ENG-PUDSP22001-R1-GEC.pdf Markup Summary

PUDSP221

**POND E1**  
**POND GRADING AND**  
**TRICKLE CHANNEL**

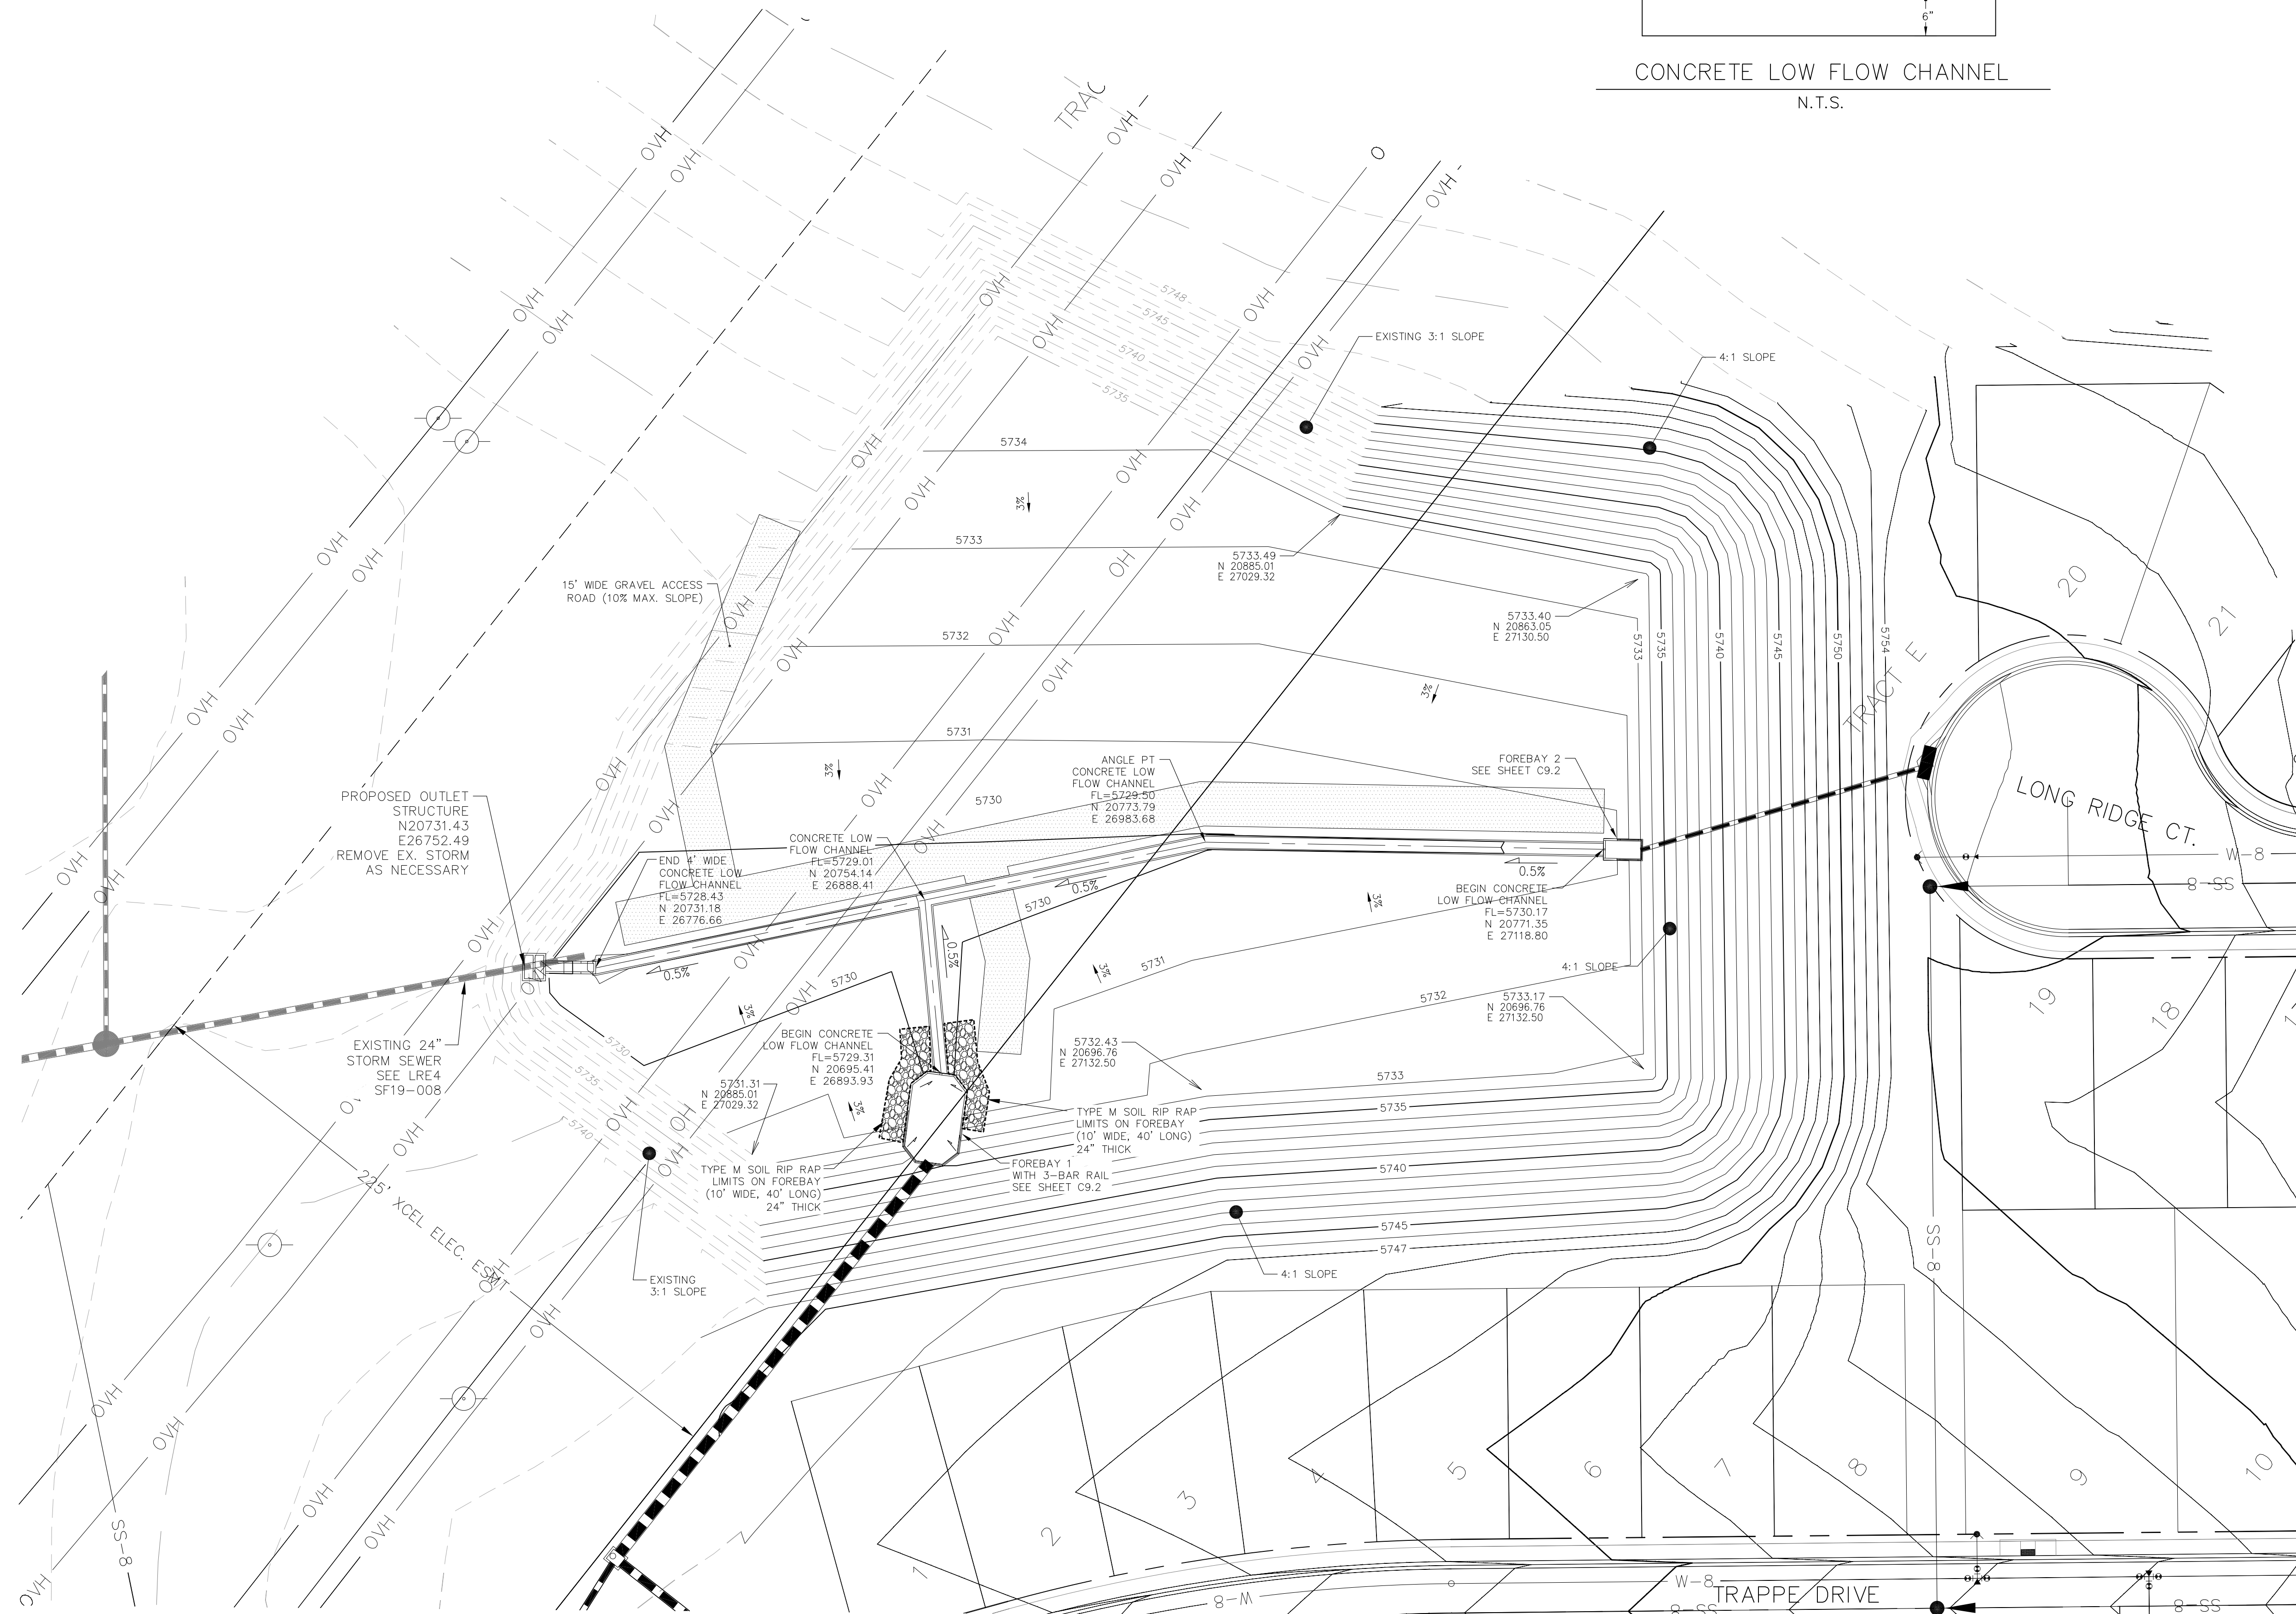
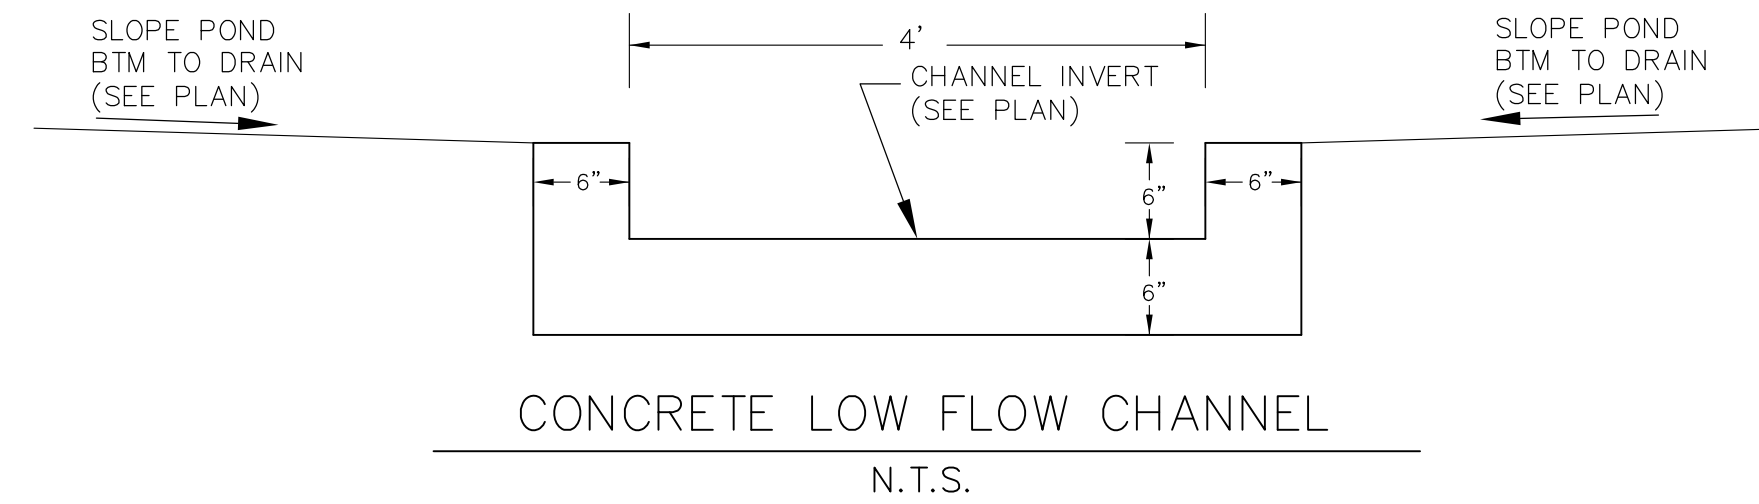
show emergency spillway and accompanying details.

provide a detail for access road like what was provided on Sht 9.4 for Pond G.
